PLAN-019510

05/09/2017

Proposal: Conversion of existing outbuilding including new pitched roof building linked to main building. This application affects the Character & Appearance of the Barnham (Church Lane) Conservation Area.

Site: 1 Little Barton, Church Lane, Barnham, PO22 0BW.
BN/24/17/PL

CLIENT	MR. & MRS. S. REDWOOD.		
SCALE	1/100	DATE	MAY 2017
DRAWN BY	REB.	DRAWING NO.	RB/SR/240/17/A (3 of 3)

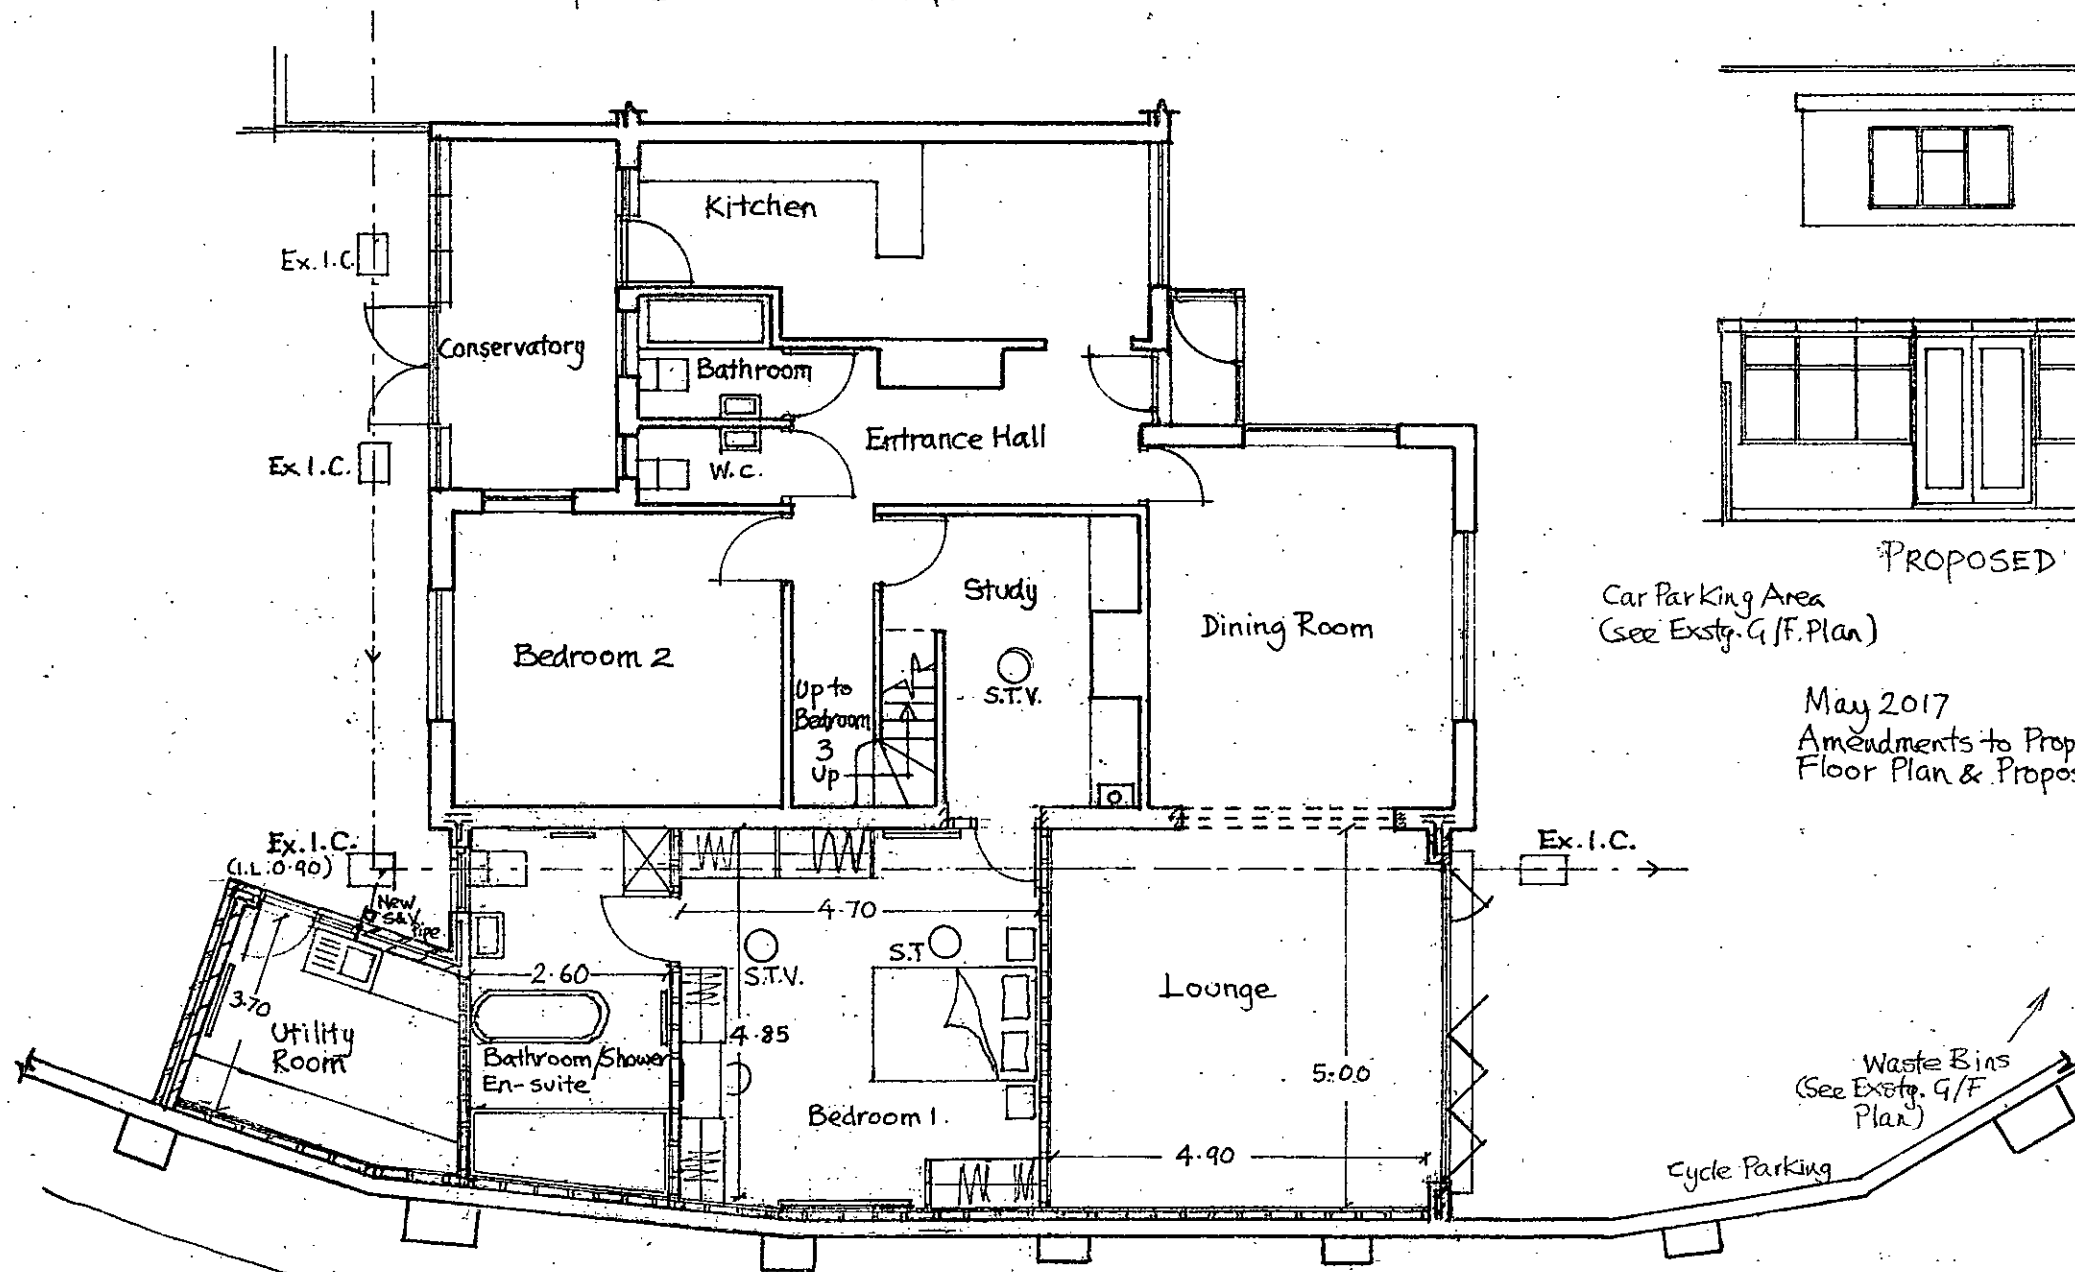
The submitted plan shows sewer serving neighbouring property and crossing the proposed site (not shown on our records). It appears that the developer is intending to build over to a public sewer. Building close/over a "public sewer" is not normally permitted by Southern Water. An investigation of the sewer is required to ascertain its condition, the number of properties served, and potential means of access, before any decision can be made as to whether it would be acceptable for the proposed development close to the sewer. Part H of the Building Regulations dictates that the matter is determined by the sewerage undertaker – in this case Southern Water.

The applicant is advised to discuss the matter further with Southern Water, Sparrowgrove House Sparrowgrove, Otterbourne, Hampshire SO21 2SW (Tel: 0330 303 0119) or www.southernwater.co.uk
